Appeal Decisions

Appeal Ref: APP/R5510/W/20/3245669

Lanz Farm, 33 Harmondsworth Lane, West Drayton, Hillingdon, Middlesex UB7 0JQ

- The appeal is made under section 78 of the Town and Country Planning Act 1990 against a refusal to grant planning permission.
 - The appeal is made by Mr M Edwards, Komfort Services against the decision of the Council of the London Borough of Hillingdon.
 - The application Ref 44185/APP/2019/866, dated 4 March 2019, was refused by notice dated 5 November 2019.
 - The development proposed is two storey rear extension.
-

PROPOSED FIRST FLOOR PLAN.

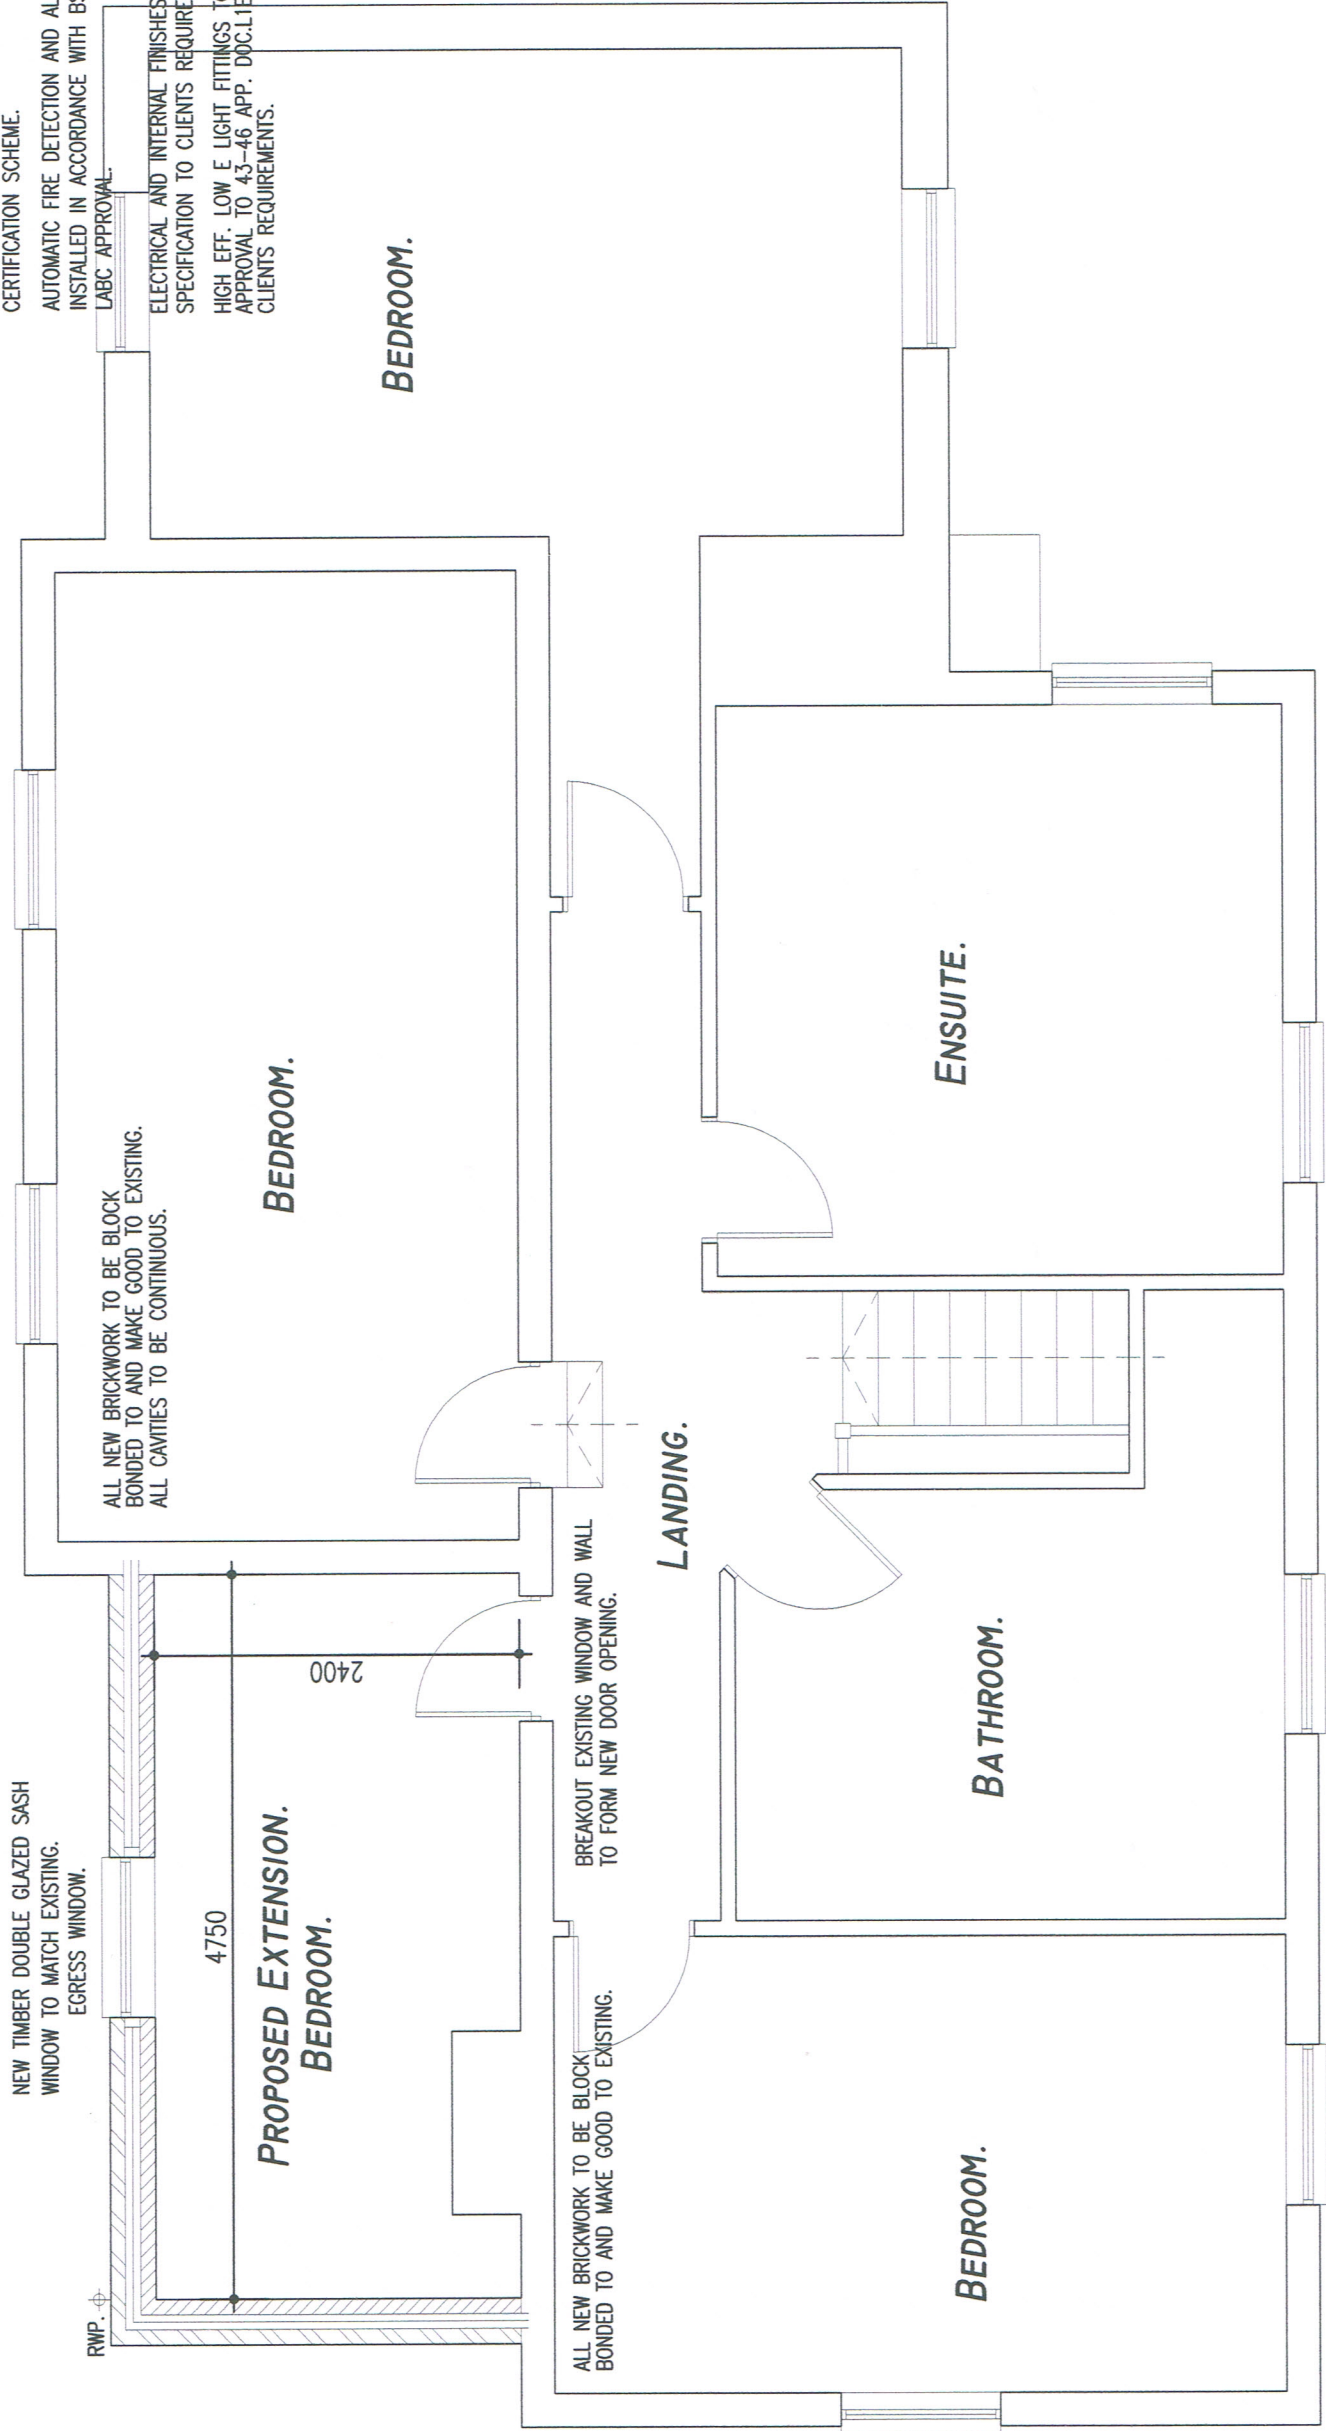
25. The proposal at first floor would involve the removal of one of the historic windows and wall below to construct a doorway through into the proposed extension. This would result in the loss of historic fabric which is identified as being of high significance in the Heritage Statement. The doorway at ground floor would be through a later element but would also result in the loss of historic fabric through the loss of the window and the widening of the opening. This also would be historically harmful given this element forms part of the development of the building and was in place at the date of listing.

Drawing: **PROPOSED ELEVATIONS.**

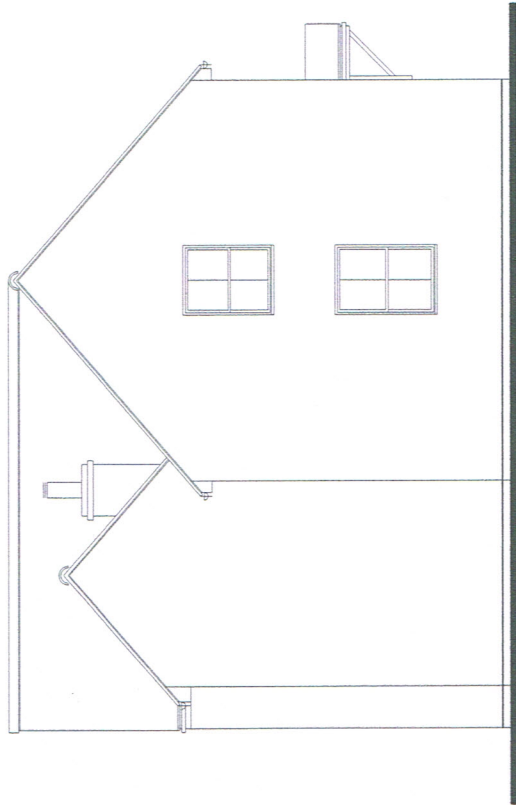
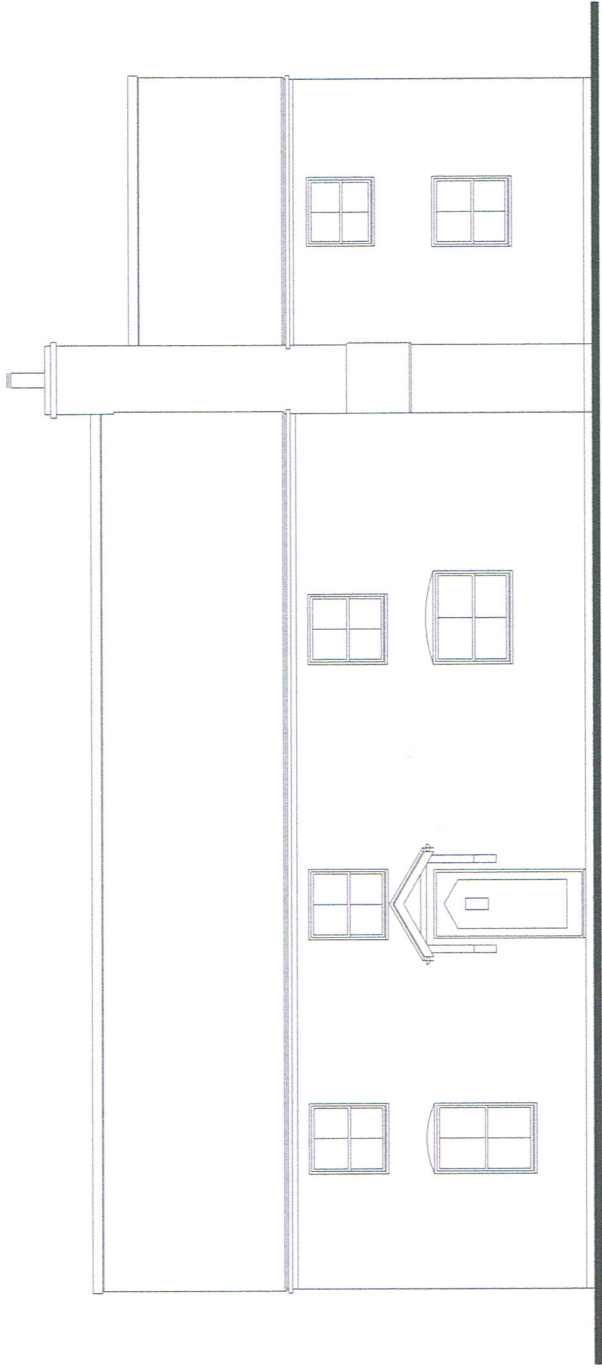
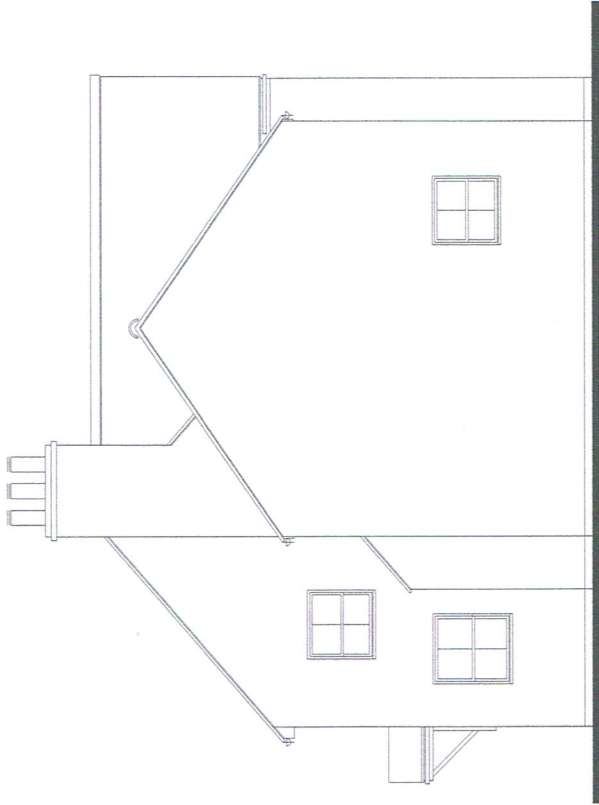
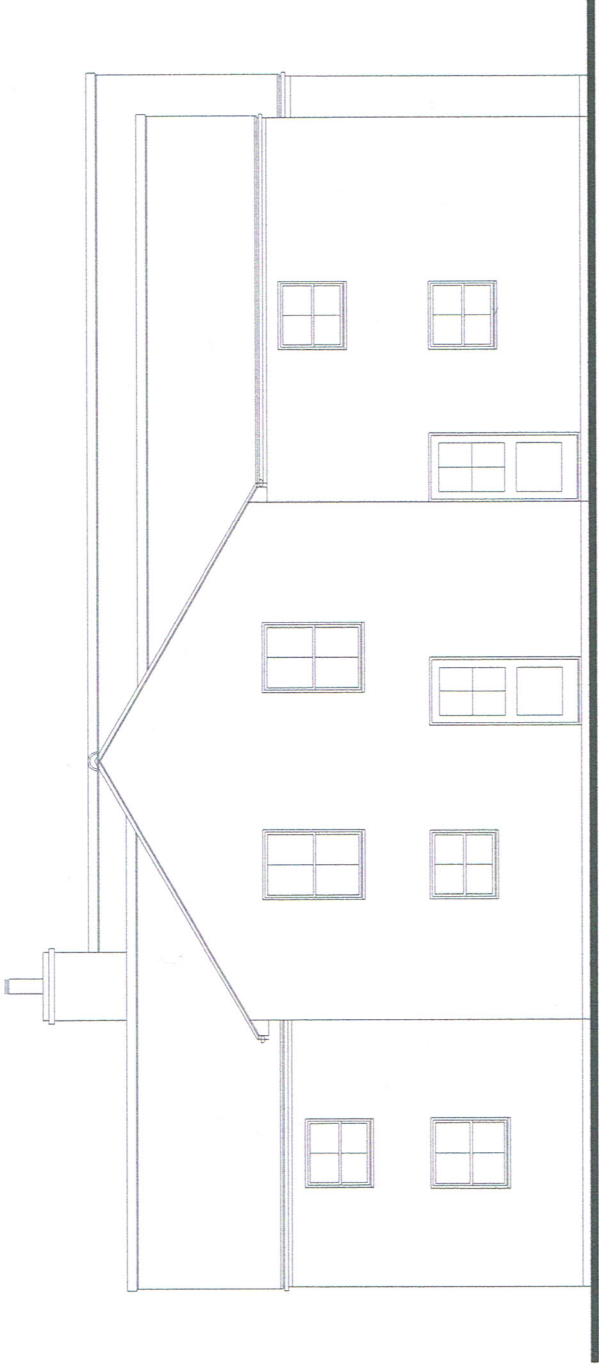
proposed extension would be seen against the existing building. However, due to the independent roof form of this proposal as a separate structure it would appear as an incongruous addition to the building not integrating into the form of the existing building.

26. Furthermore, the proposal would result in the obscuring of the majority of the height of the existing chimney which forms part of the significance of the building both of itself and when viewed externally from the public domain. While this section was not part of the earliest parts of the building, being beyond the original jettied first floor, it is still identified as being of high significance and forms part of the early historic development of the building.

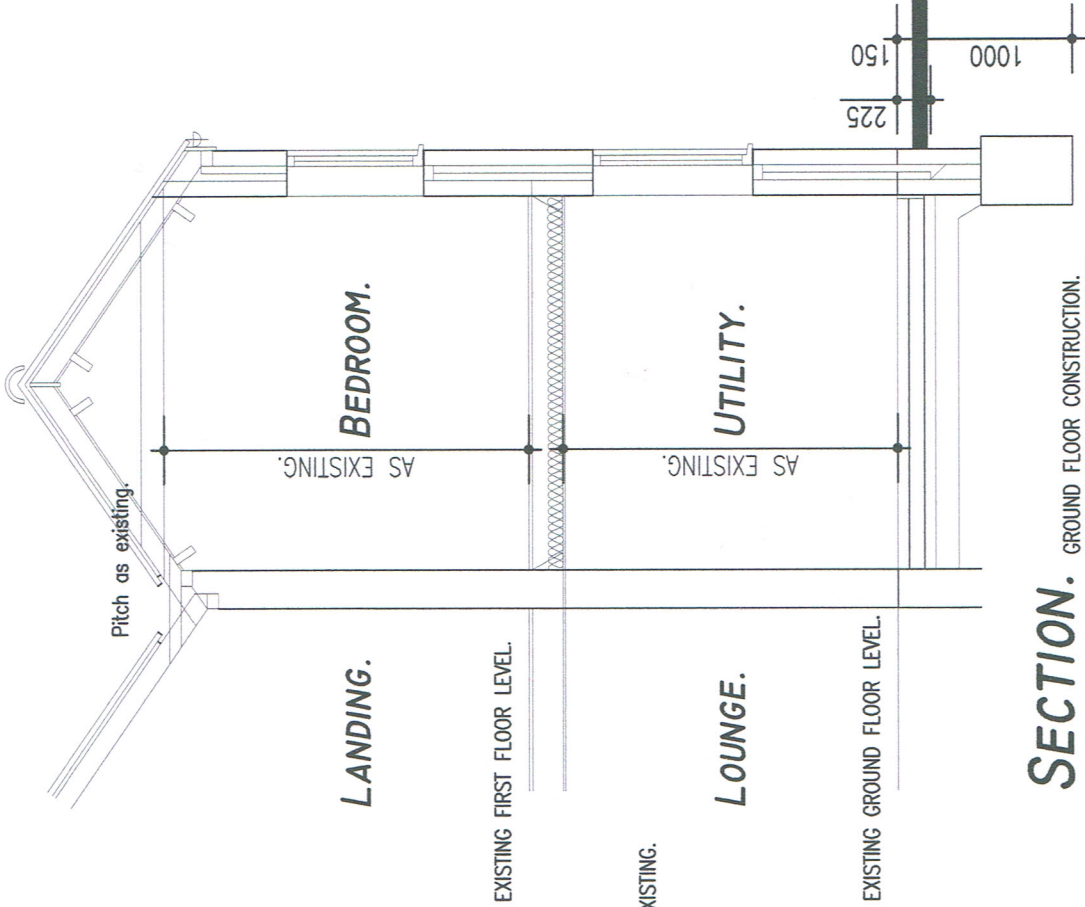
27. The integration of the proposed extension into the existing building would result in the loss of historic fabric and it has not been demonstrated how this would be satisfactorily achieved, particularly at roof level with the existing, partially exposed, roof structure and the need to shed rain water given the proposed roof valley. Given the importance of the timber frame to the significance of the heritage asset and the risk of water damage, I consider that this should not be left to later resolution.
